Planning Application Ref: F/11/19/PL

Location: Wicks Farm, Ford Lane, Ford, BN18 0DF

Description of works: Construction of agricultural barn with flexible storage use (B8 Use Class) with ancillary office space

Drawing Name
Site Plans

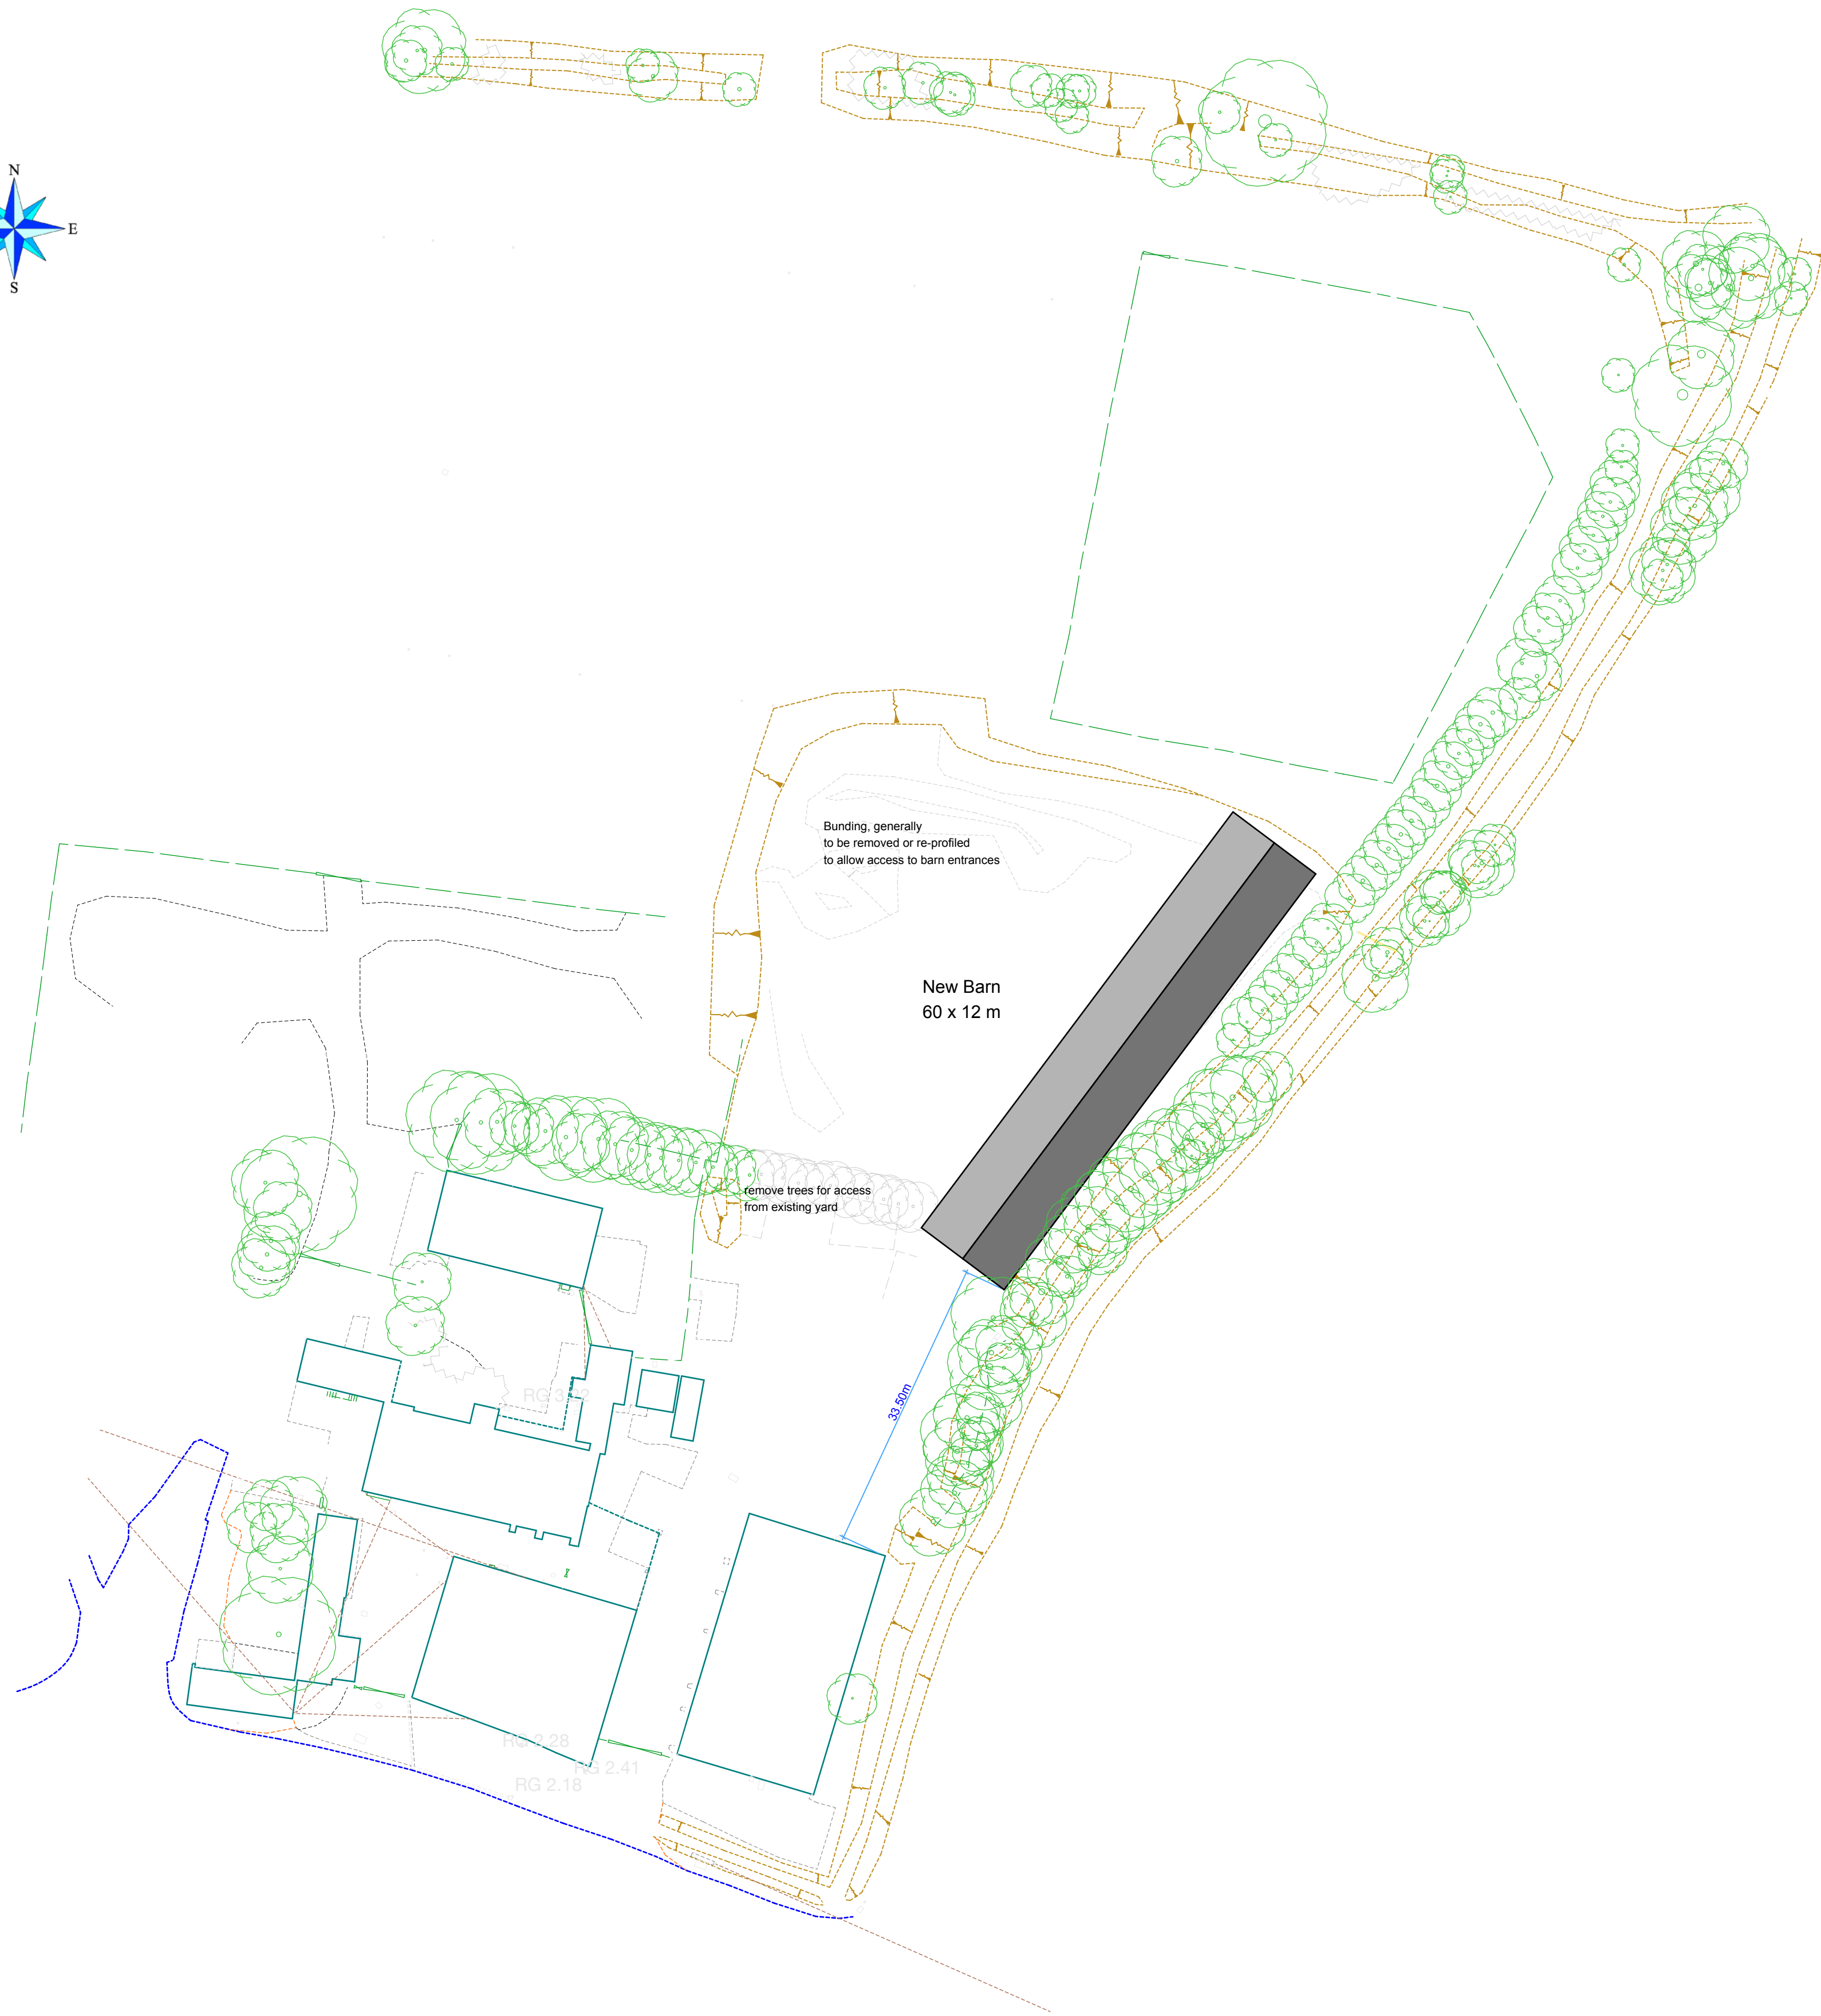
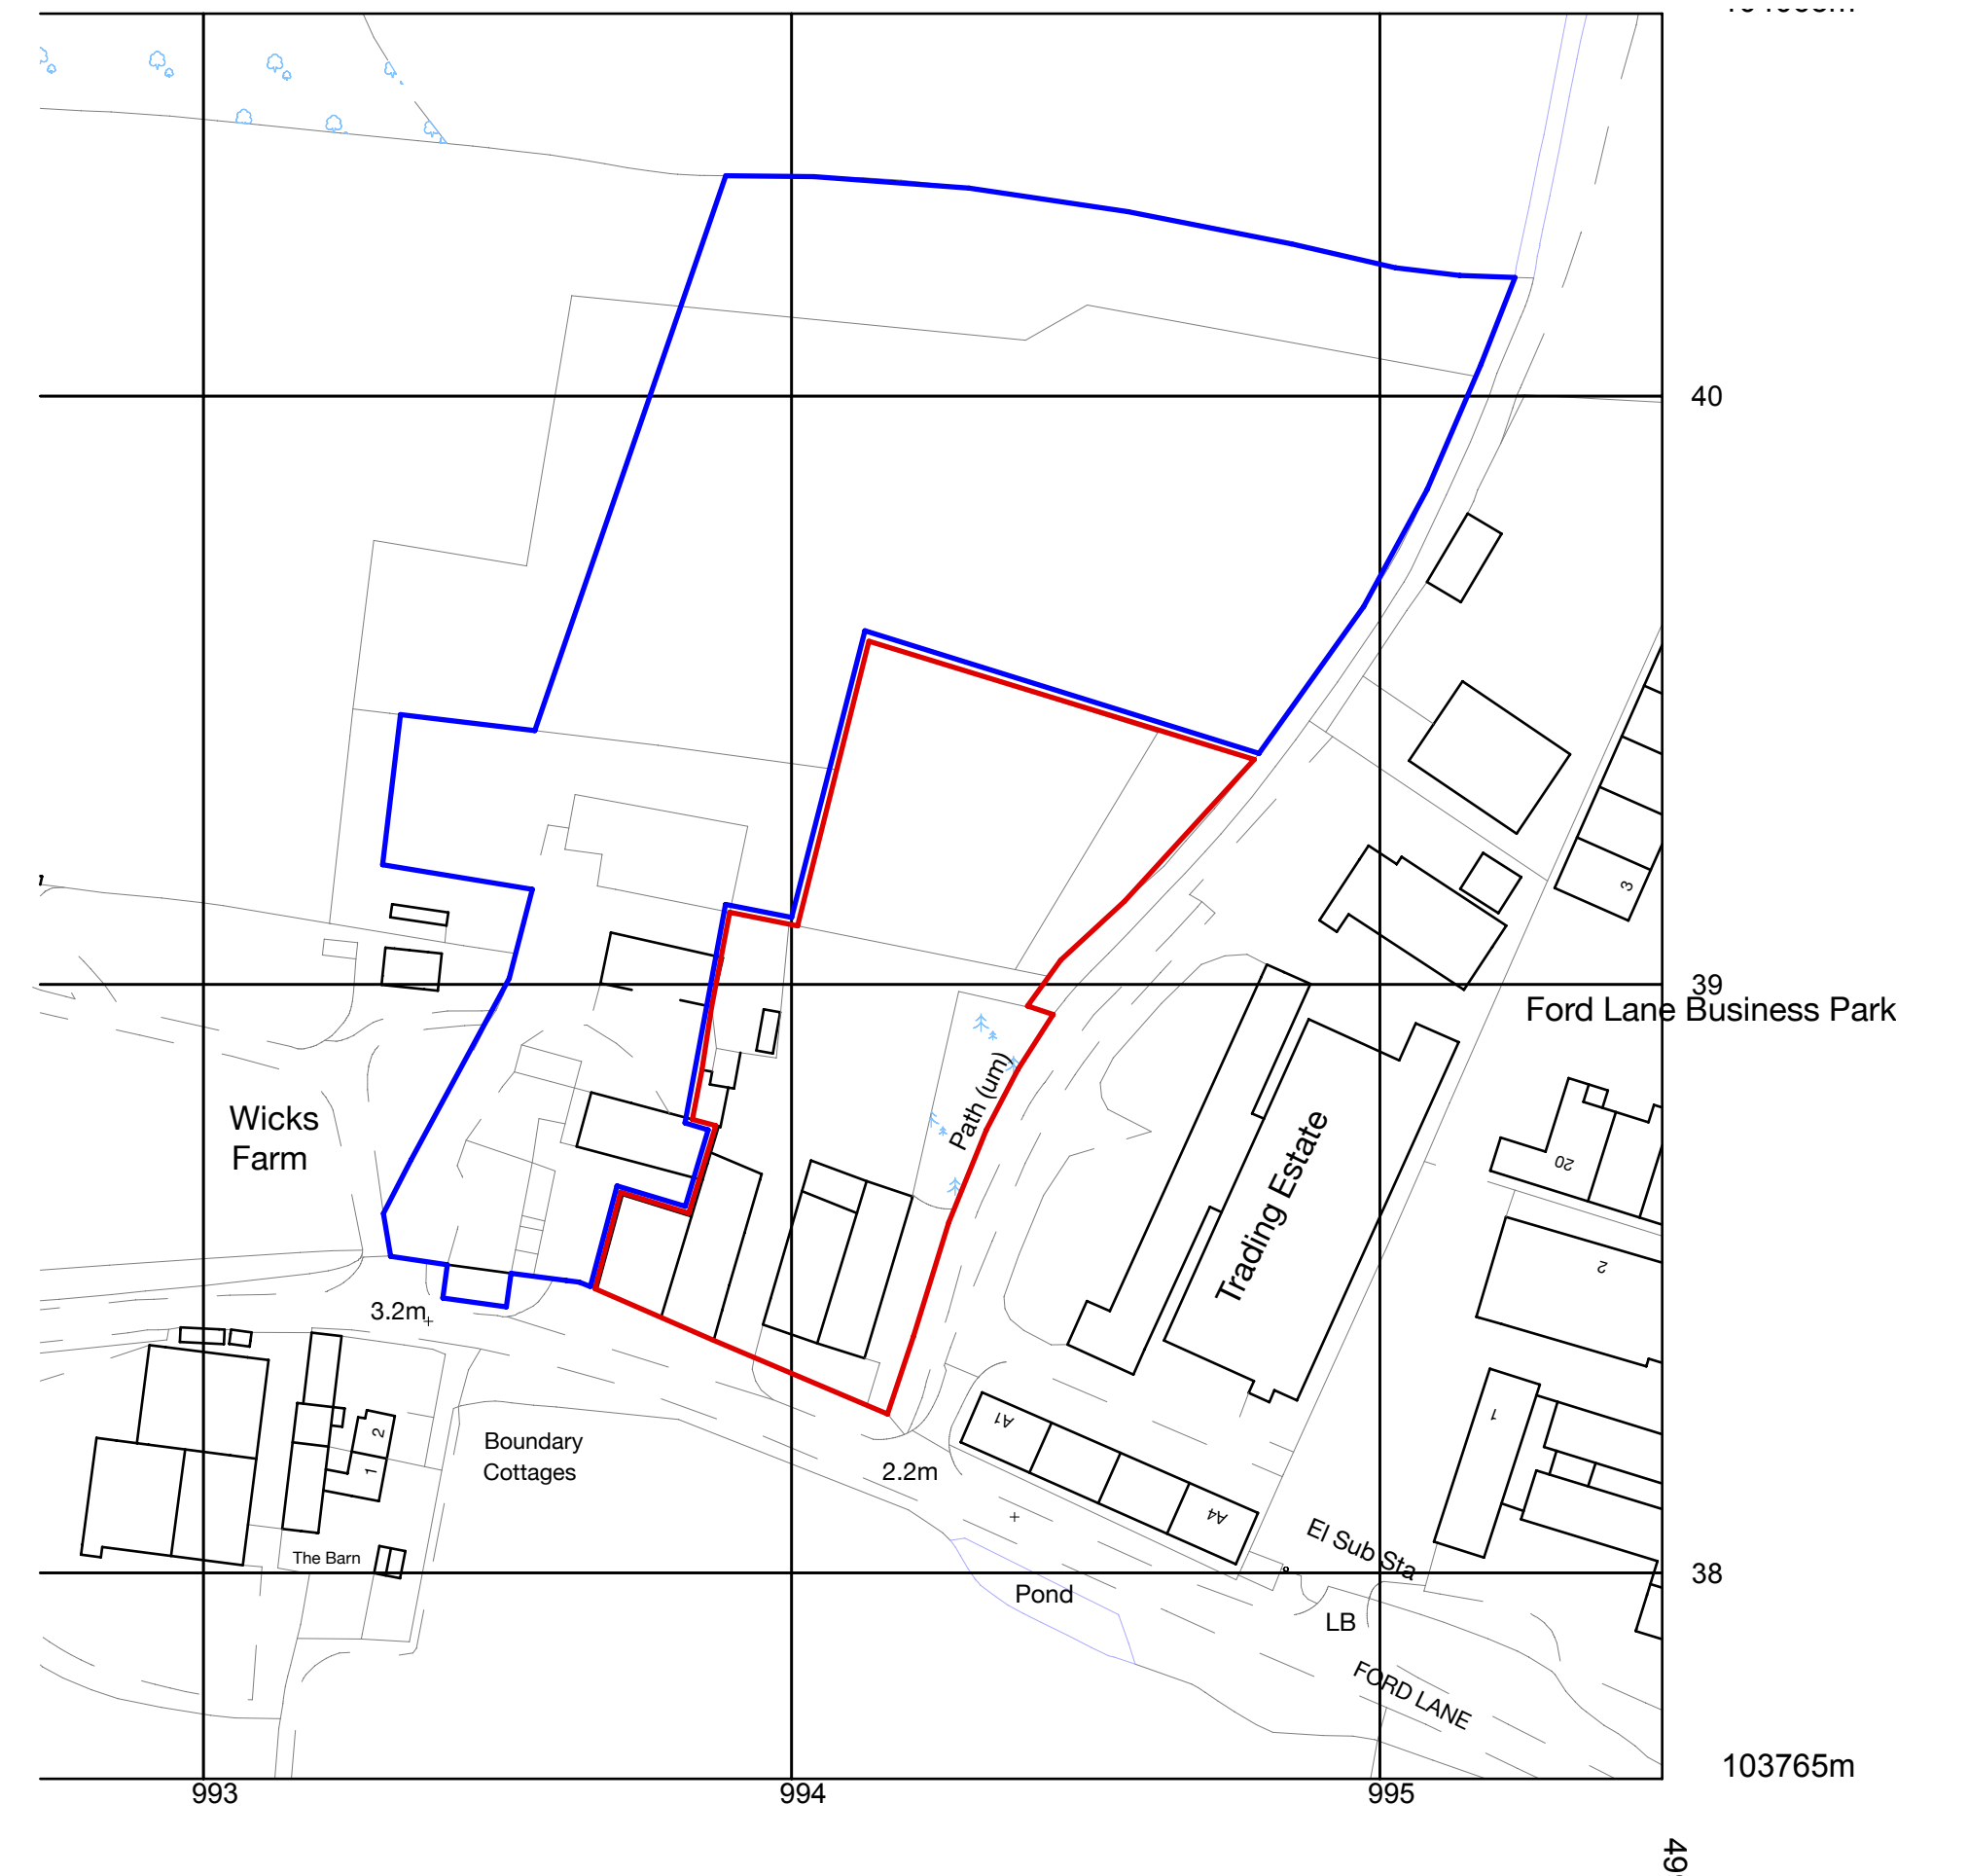
- There is a large number of poplar trees in linear grouping along the site's east boundary, a substantial landscape feature and acting as a shelterbelt to the adjacent trading estate/business park. A smaller group of the same tree type and formation runs east to west across part of the plot interior, some of which is proposed for removal to facilitate adequate vehicle access to and from the new barn.

- The proposal appears to be sympathetic to the existing and future growth of the majority of those trees and has the potential to be harmonious, although the application is a long way from having established that will be achieved.

- There are significant trees on this site which could be adversely affected by the proposals. There is no supporting arboricultural information submitted with the application - a requirement of BS5837:2012. As such, were this application to now proceed, we will not have sufficient information to guarantee such trees would be adequately respected and protected.

- As a general principle of design, careful consideration should be given to the intended land use beneath existing canopy of established trees and the potential for further tree growth (root and crown extension). With such a large and open site to work with I would expect a layout proposal to have placed great emphasis on eliminating future 'pressure to prune or removal' of retained trees. Furthermore, there would need to be a compelling argument in favour of any Root Protection Area incursion as this site clearly lends itself to a harmonious design that avoids any direct interference with established trees of current and future landscape value.

1. The applicants will need to employ the services of an Arboricultural Consultant to carry out a tree survey exercise and then prepare an Arboricultural Implications Assessment (AIA) which must be inclusive of; a 'Tree Survey Schedule', a 'Root Protection Area (RPA) Schedule' and a 'Tree Constraints Plan' – with the trees accurately plotted on same.
2. In the event that a RPA of any tree which is proposed for retention overlaps the development then BS5837:2012 requires that the Detailed Planning Application is accompanied by an Arboricultural Method Statement (AMS) and also most importantly a Tree Protection Plan – to both describe and illustrate the mitigation measures which are to be employed to ensure that the trees survive without detriment to their vigour and vitality and are given adequate protection both above and below ground.
